OBERON COUNCIL

29 November 2021

MODIFICATION OF STATE SIGNIFICANT DEVELOPMENT – SSD 7016 MOD 4 – 124 LOWES MOUNT ROAD, OBERON - BORG MANUFACTURING PTY LTD

SCALE 1:600 FOR A1 OR 1:1200 FOR A3	Stage DA
Project Number 2021/01	Issue A
Drawing Number DA100

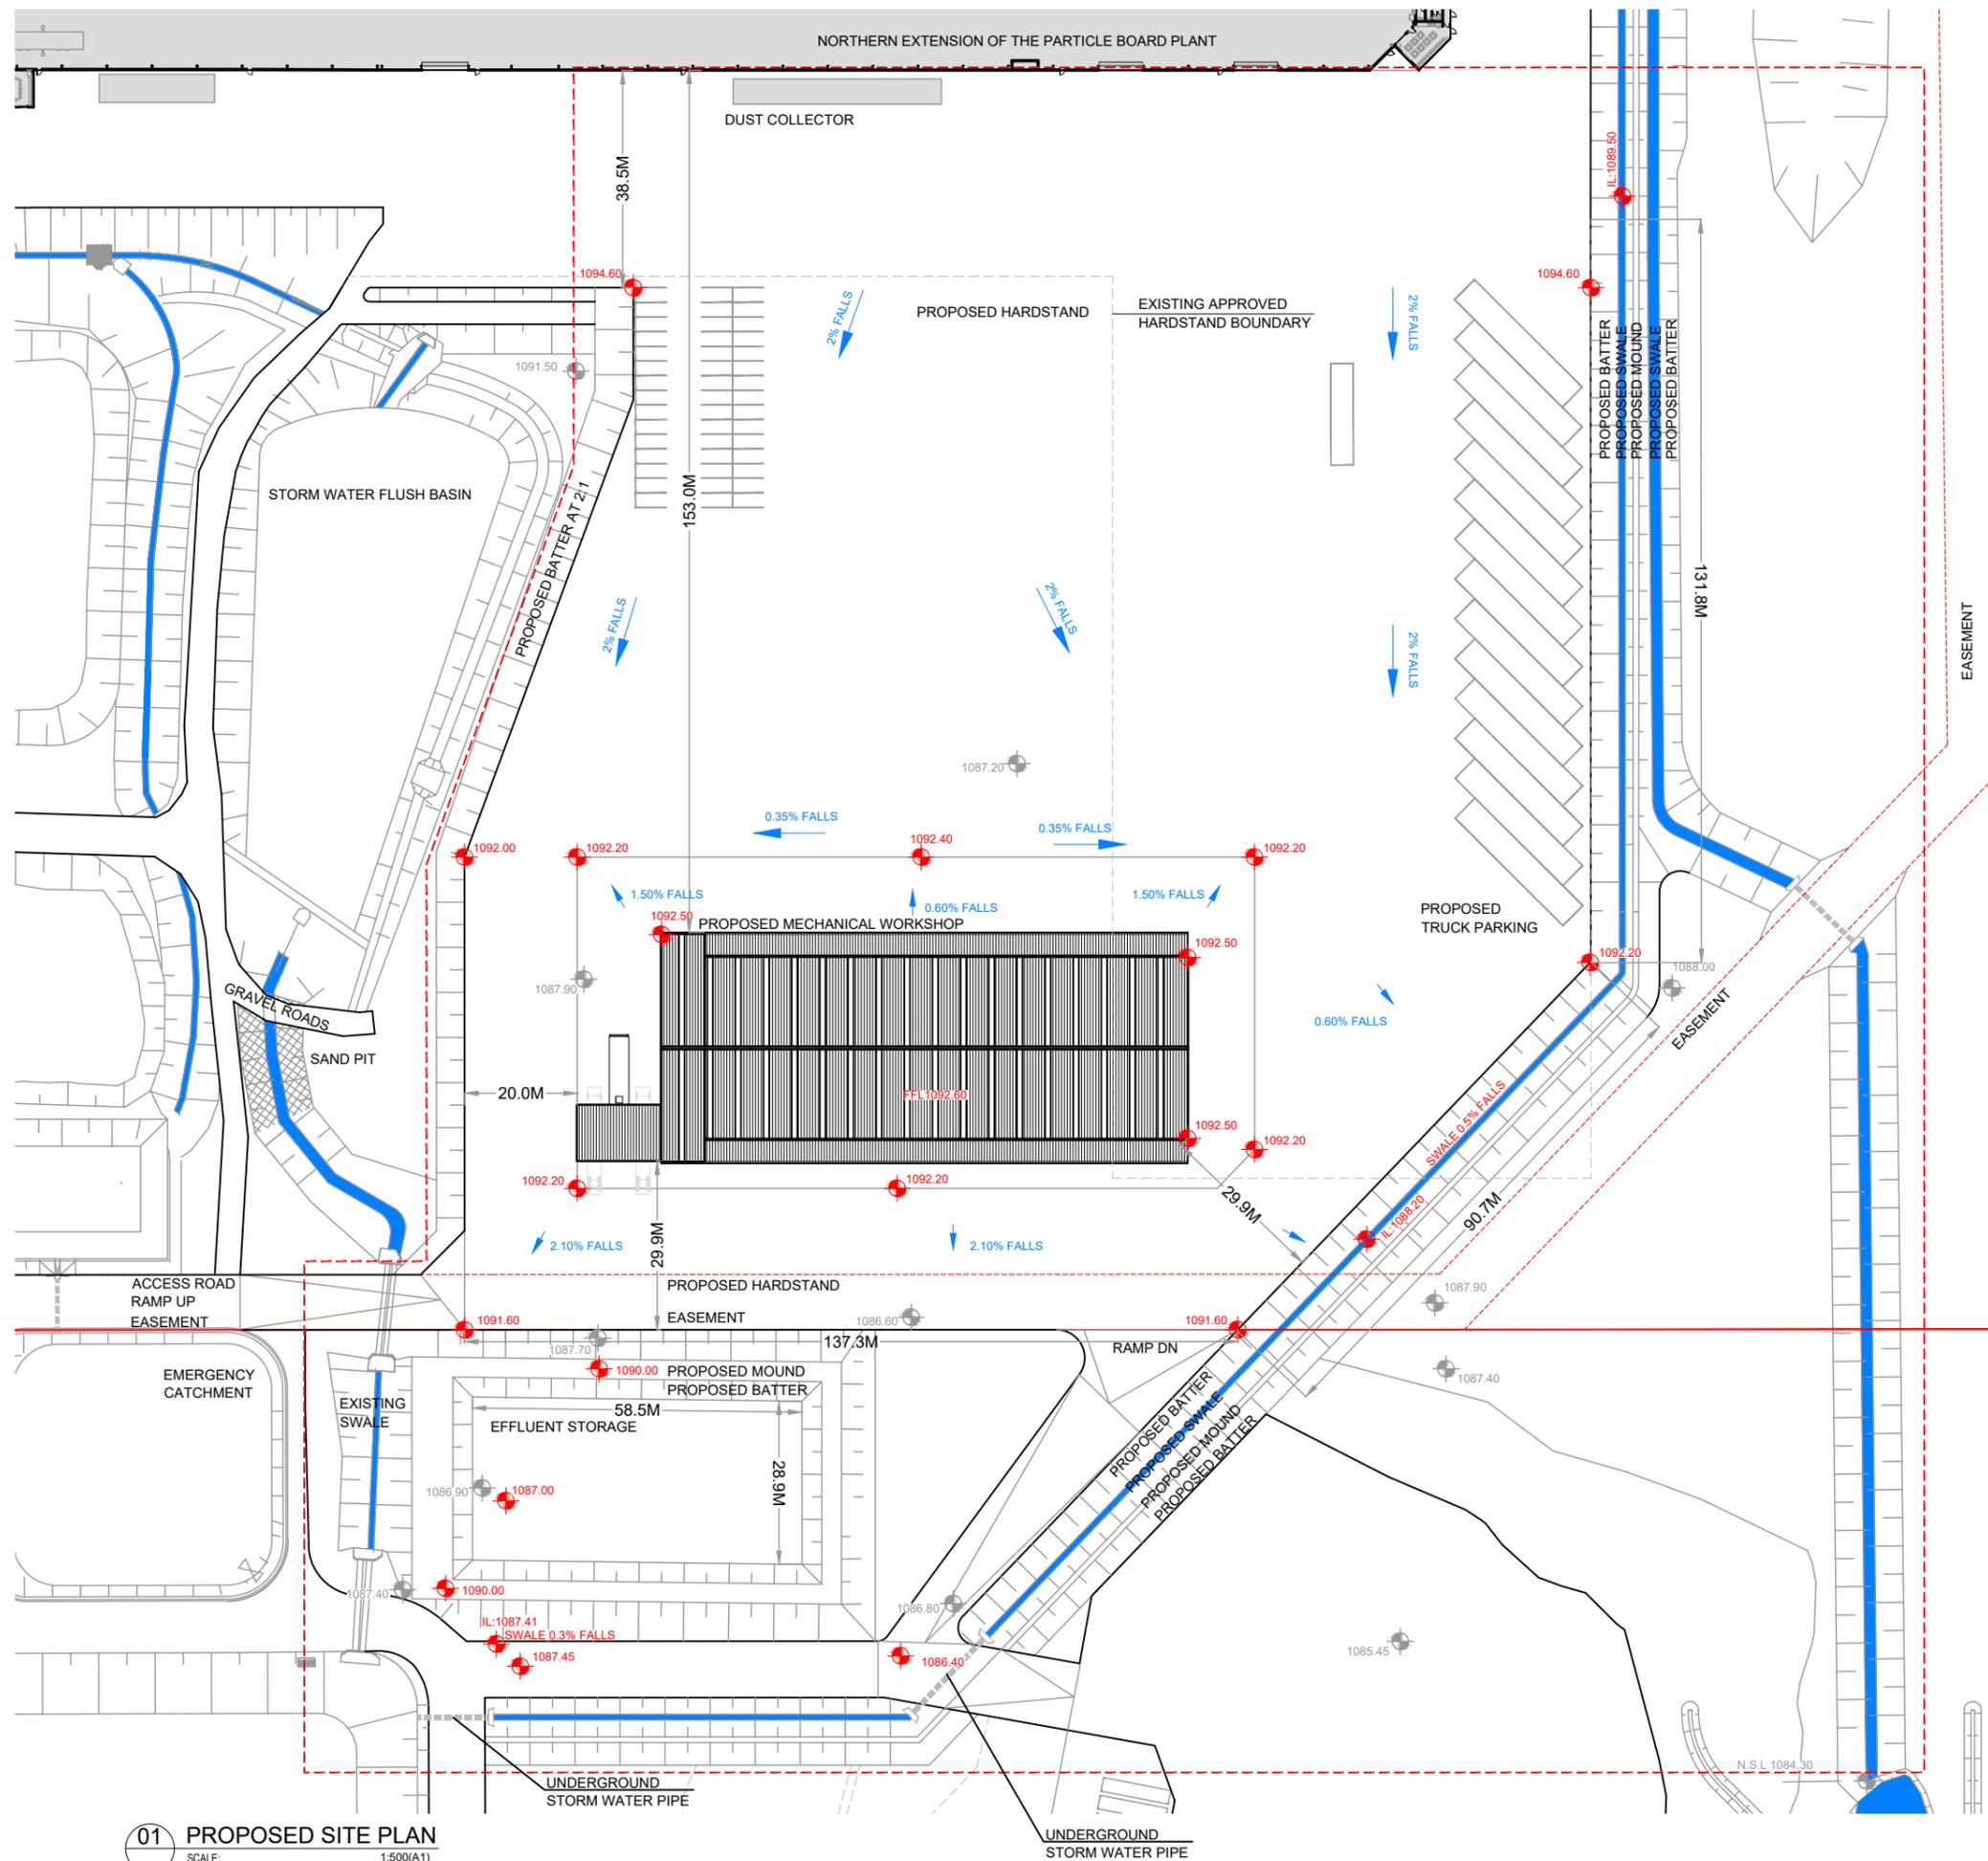
3. The proposed modification includes a significant enlarging of a “hardstand” area. At one point in the SEE, it is referred to as the “new concrete hardstand”, but other references to concrete surfacing apply only to the new mechanical repair workshop. It is unclear what the surface treatment of the whole of this hardstand area is proposed to be. If any of the surface area where trucks and other vehicles are to be driving is compacted dirt, Council is concerned at the potential for sediment to be tracked from this area onto surrounding roads. An inspection of Endeavour Road on 26 November 2021 found that significant dirt is currently being tracked onto the road. The sealing of the driveway to the hardstand area will assist in reducing this impact, but it is unclear if the proposed automated truck washing machine will adequately prevent any dirt tacking onto the road.
